22 October 2010

**Major Project – MP10_0060 – Exhibition of Environmental Assessment –
Redevelopment of Sydney Fish Markets**

Allan Young
Manager Property Planning
Property, Planning & Infrastructure Division

■ Reed bed

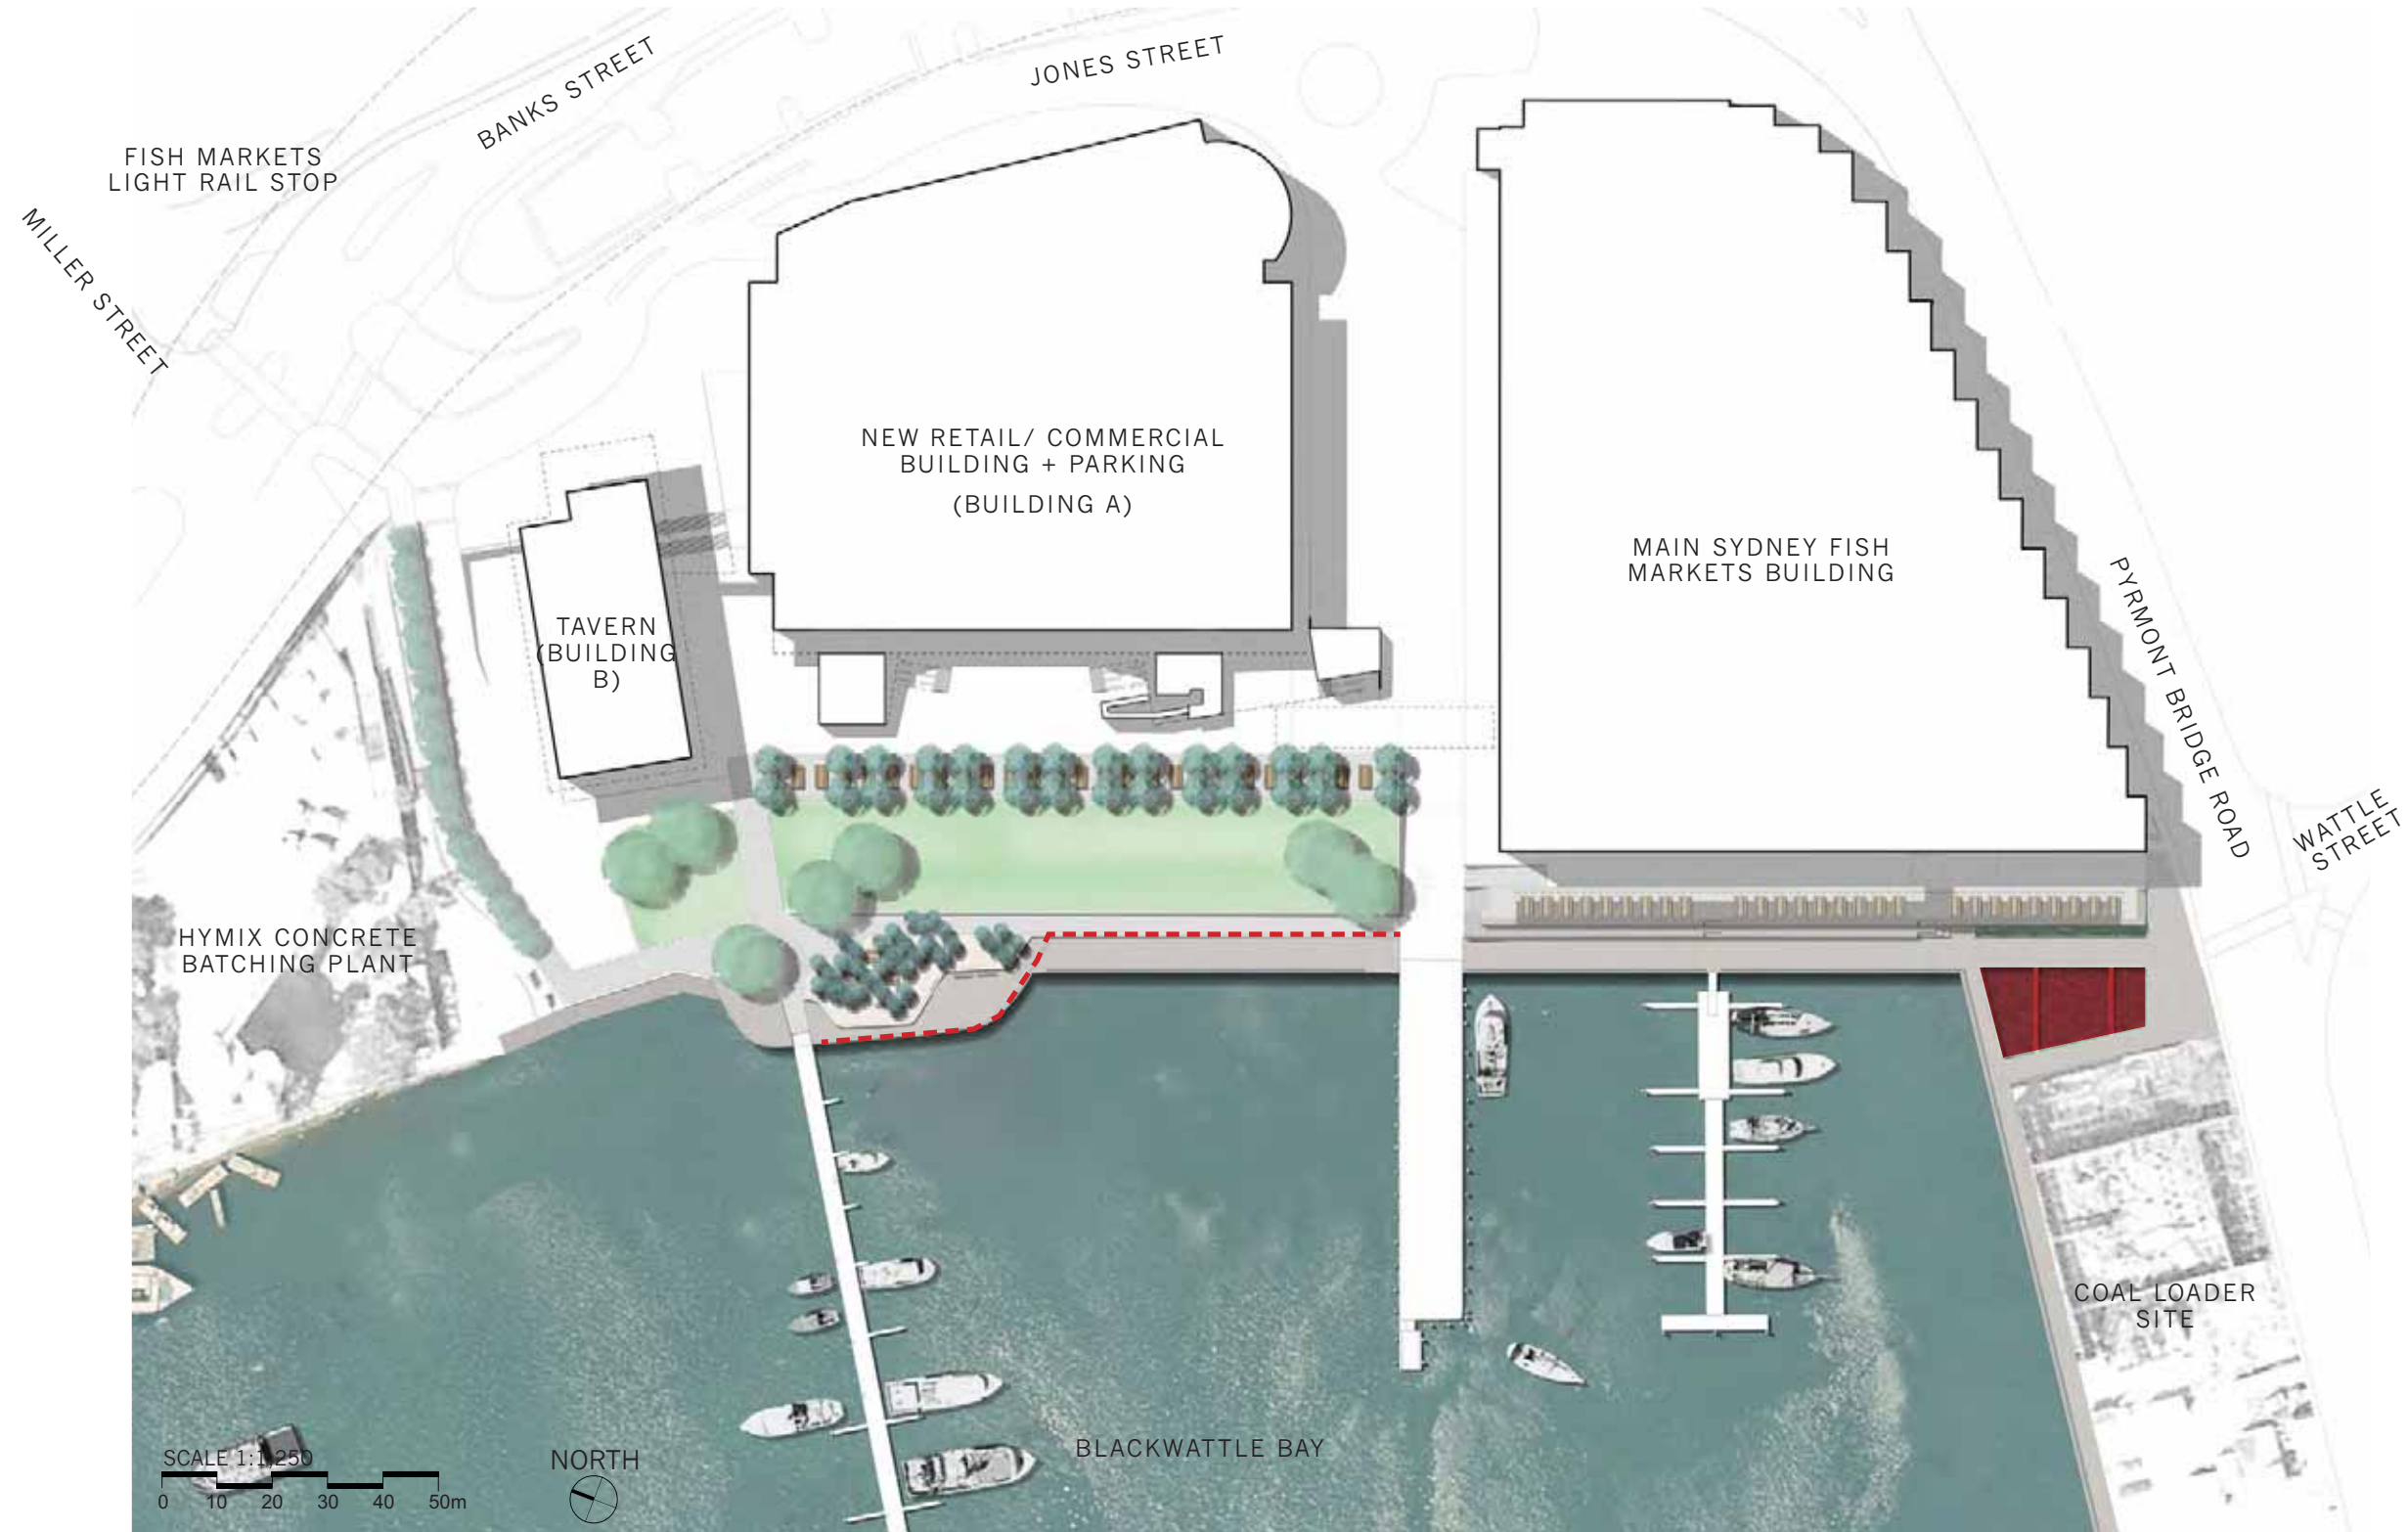
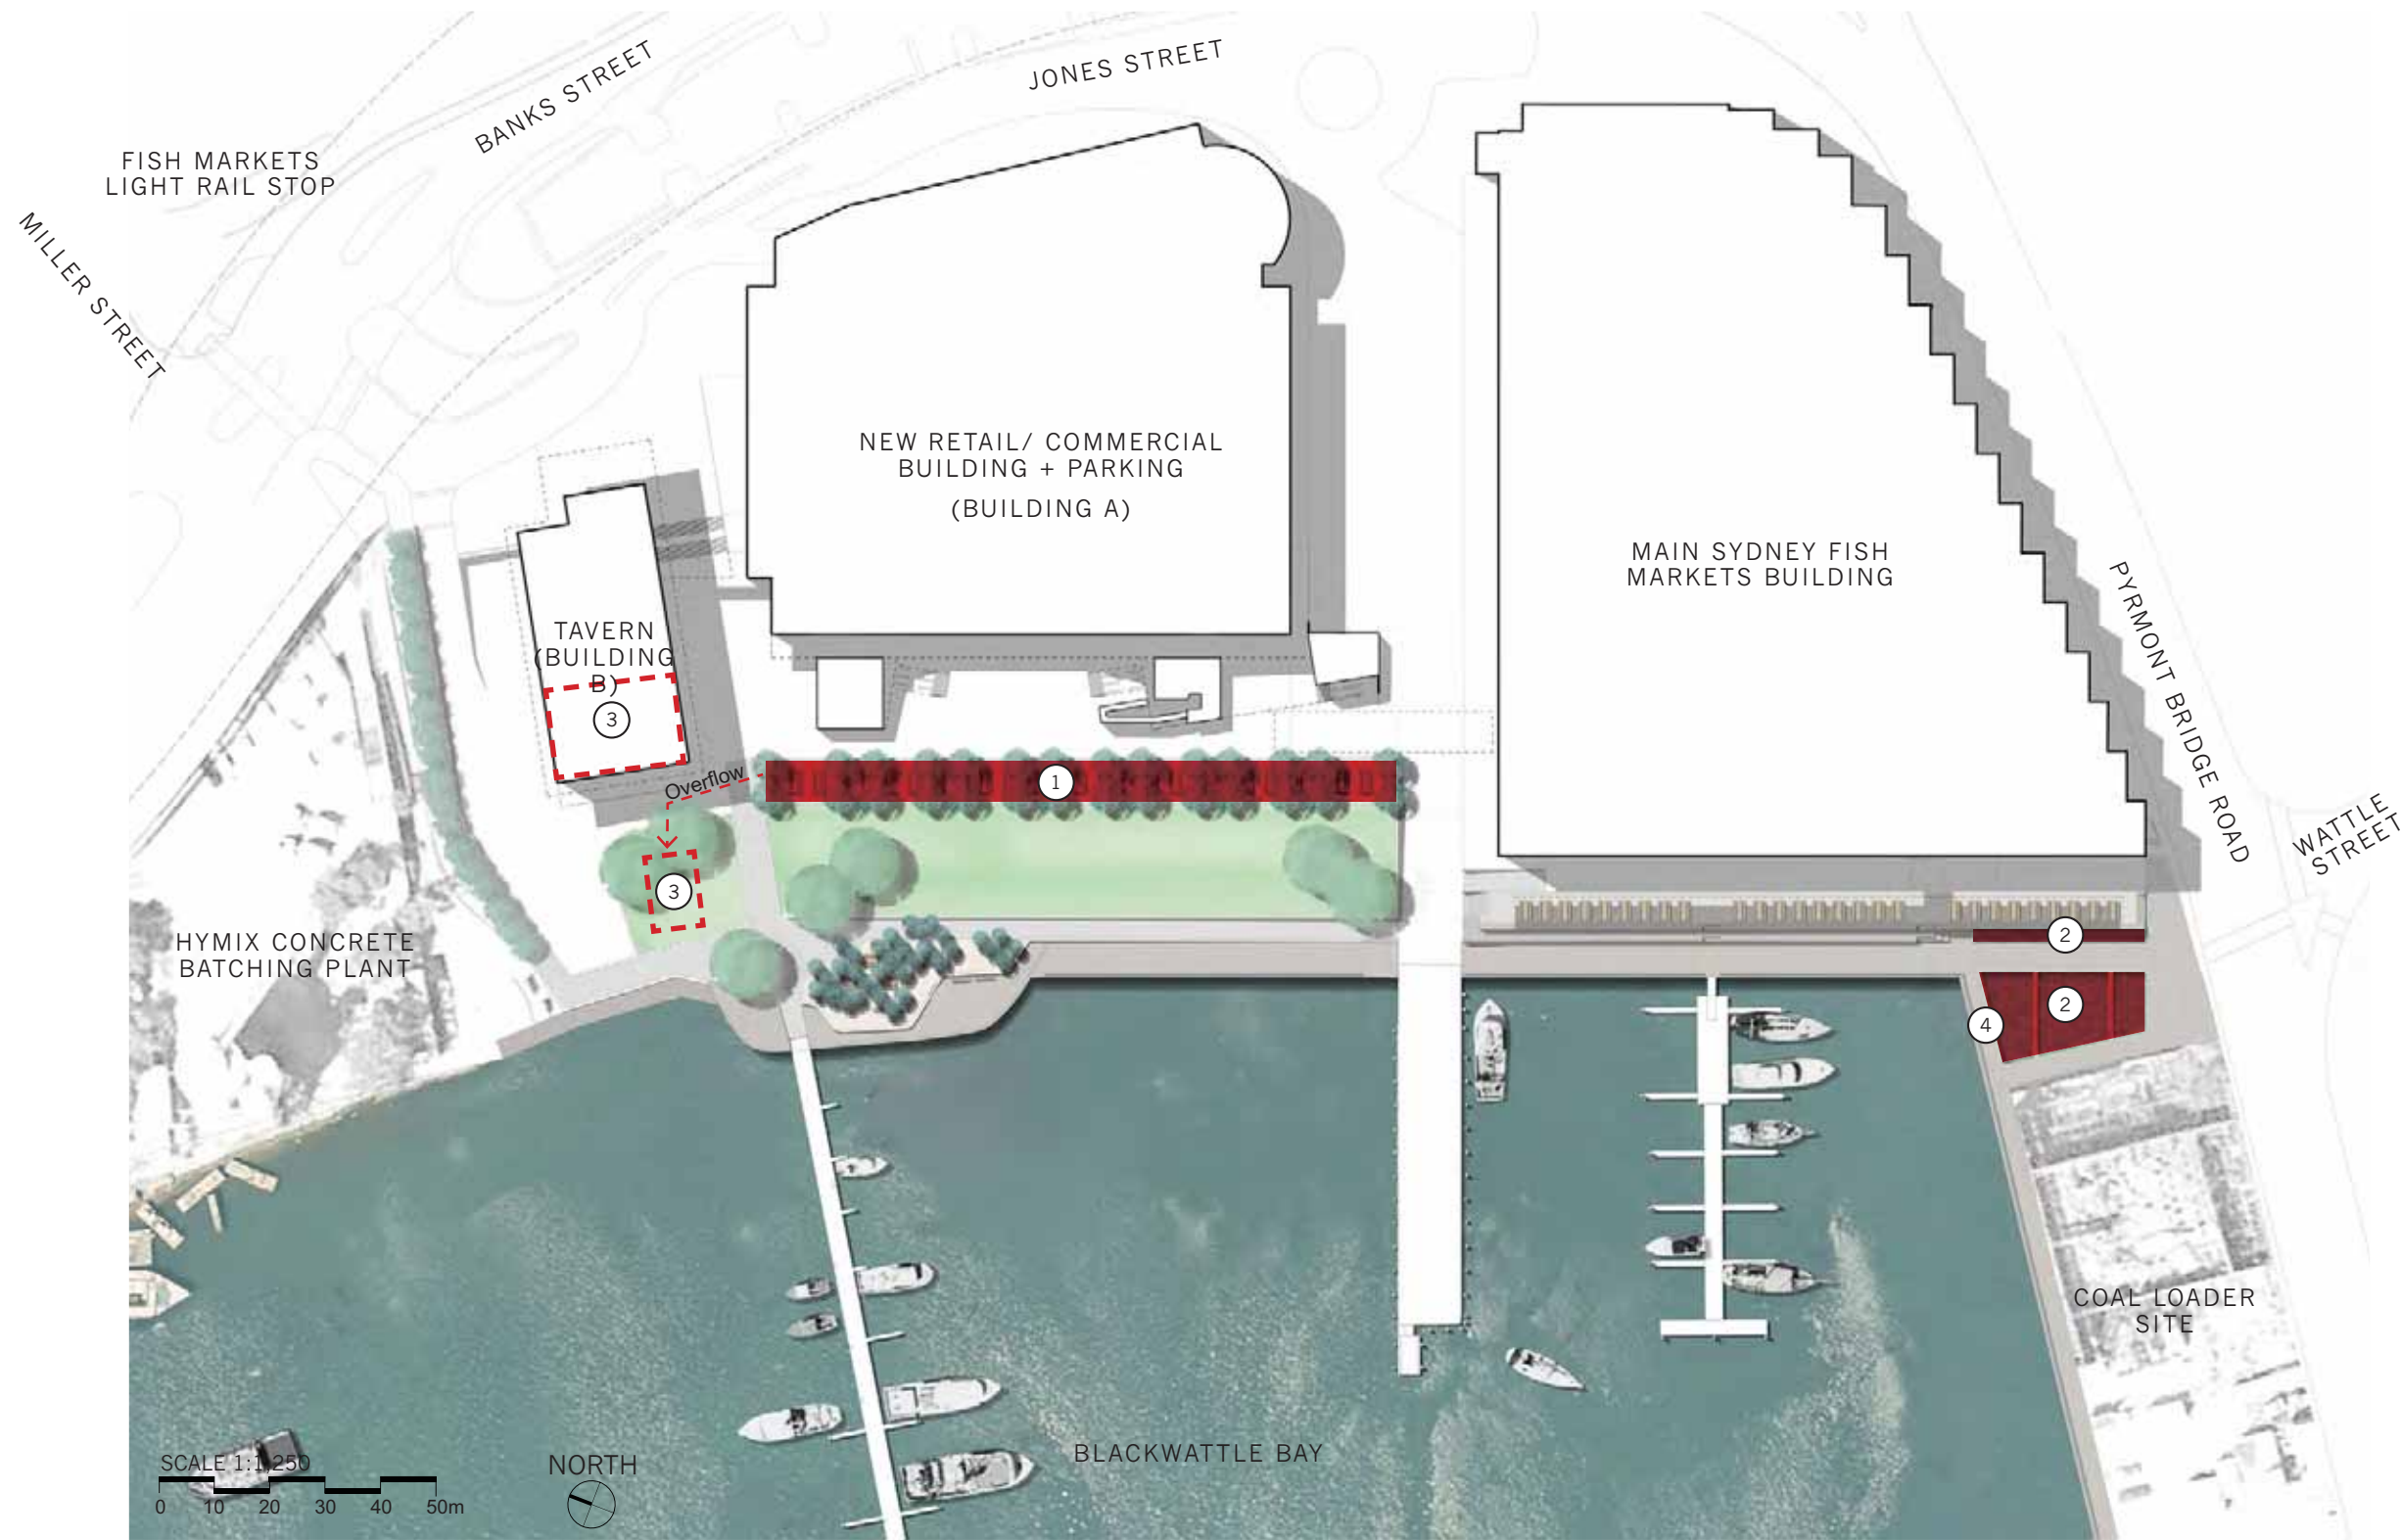
1. The proposed bio-retention system (reed bed) and contiguous area of the promenade boardwalk, extending west, directly adjoins the NSW Maritime (NSWM) site for the proposed Blackwattle Bay Marina (BBM). Prior to finalisation of the application the following additional and further information is requested:

- a) Details of the scheduling for the construction of these elements. In order to permit the timely progression of the adjoining development site, scheduling of these works should be done in consultation with NSW Maritime to ensure that the westerly sea wall does not become obstructed and prevent remedial works;

- b) Detailed design of the proposed reed bed and the boardwalk interface, including levels, demonstrating that adequate and ongoing access to the adjoining westerly sea wall is maintained. Any design should be coordinated with NSW Maritime;
